# CITY OF ALBUQUERQUE

November 13, 2018

**RE: Overture Senior Active Adult  
6410 Palomas Ave NE  
Grading and Drainage Plan  
Engineer's Stamp Date: 10/17/18  
Hydrology File: D18D056A**

**RE: OVERTURE SENIOR ACTIVE ADULT  
GRADING AND DRAINAGE (FILE: D18D056A)**

ENGINEER'S SEAL JOEL D. HERNANDEZ P.E. #17893	OVERTURE SENIOR ACTIVE ADULT GRADING AND DRAINAGE PLAN TIERRA WEST, LLC 5571 MIDWAY PARK PLACE NE ALBUQUERQUE, NM 87109 (505) 858-3100 www.tierrawestllc.com	DRAWN BY DY DATE 9/20/18 2017086-GRB
		SHEET # C2 JOB # 2017086

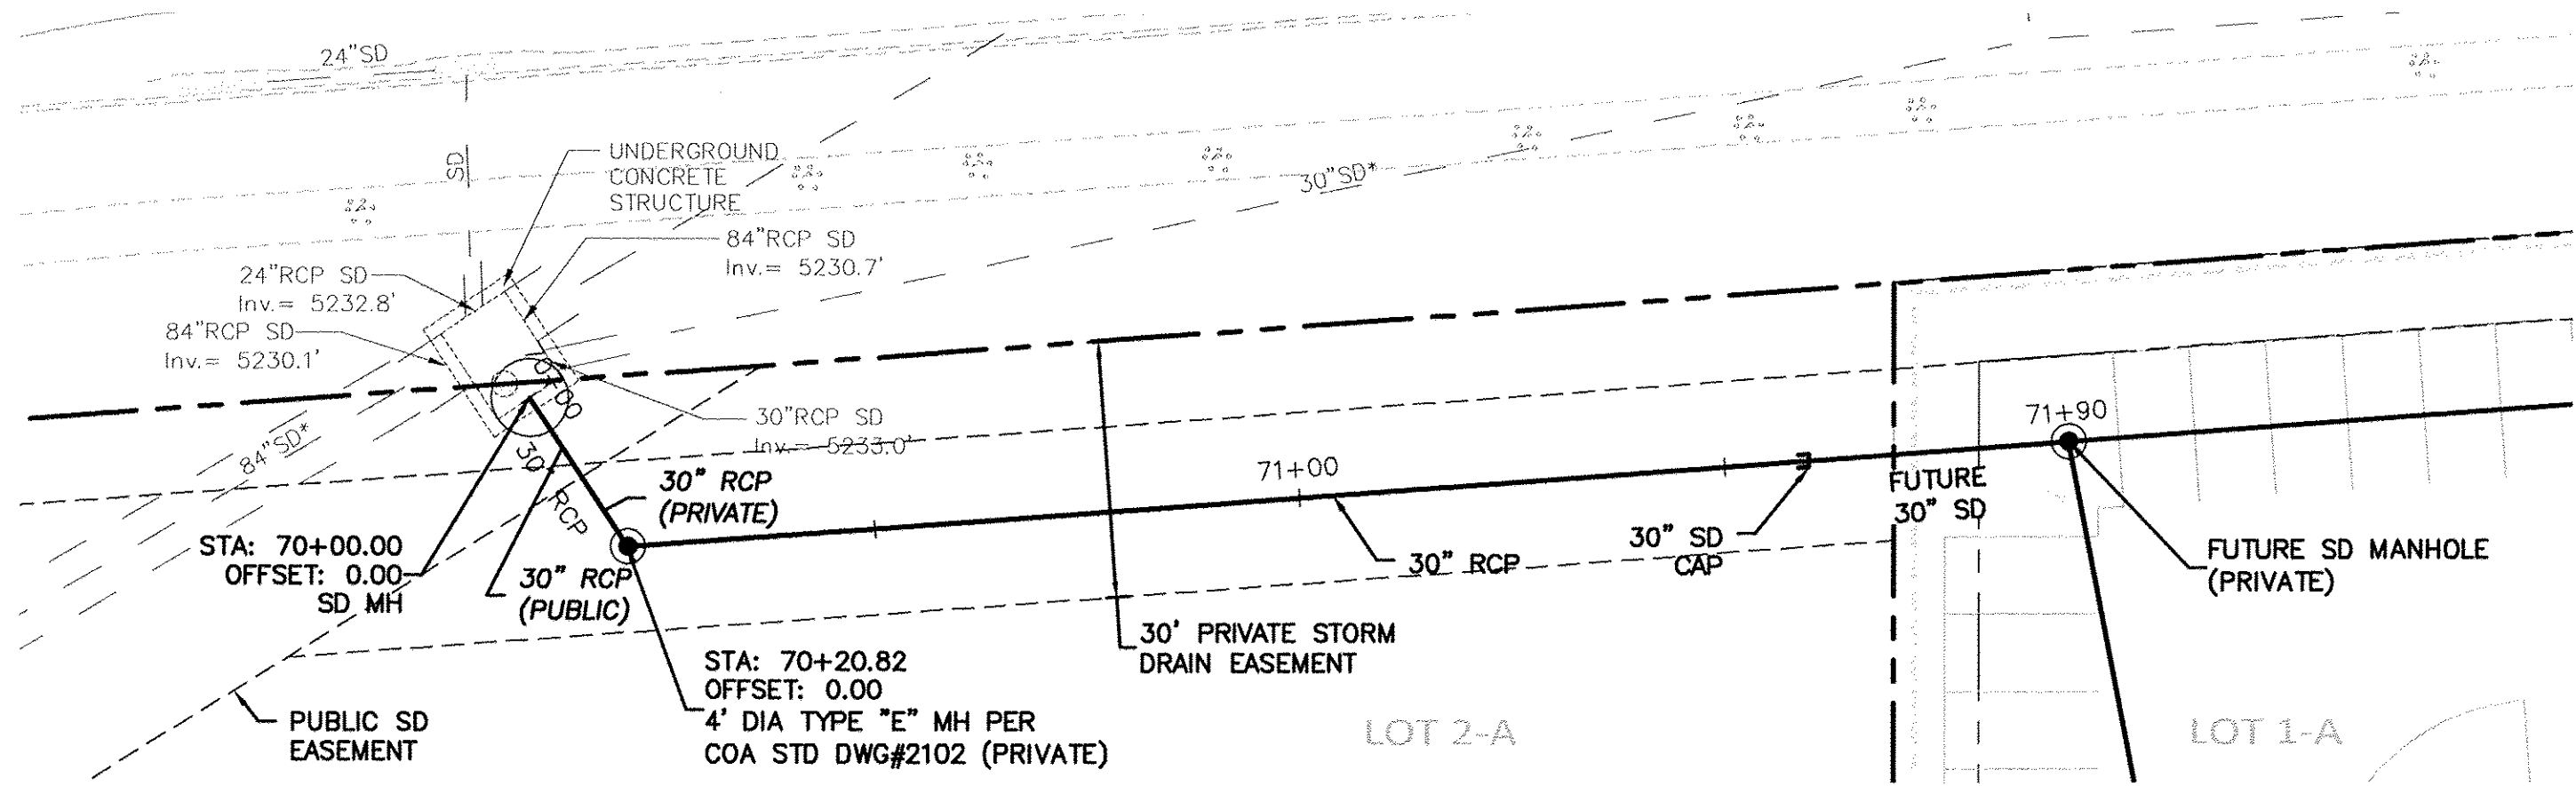
2. Please provide the FIRM Map's effective date.

3. Please provide the benchmark information for the survey contour information provided.

5. Please add a note requesting a waiver for the first flush volume requirement. Also add a note stating, "The required first flush volume for the 142,764.70 SF of impervious cover is 4,045 CF."

**RESPONSE: The FIRM Map's effective date is 08/16/2012. We added this notation to Sheet C2.**

**RESPONSE: We added the benchmark information to Sheet C2 (located in Paseo Del Norte sidewalk, near northeasterly property corner).**

**RESPONSE: We have added a note indicating the first flush requirement and formally requesting a waiver to allow in-lieu fee payment onto Sheet C2.**

4. Please provide a section of the proposed retaining wall along Paseo del Norte near the Northwest corner of the site and a section of the proposed retaining wall along the western property line.

**RESPONSE: The section views requested are now included on an added Sheet C2.1 for clarity.**
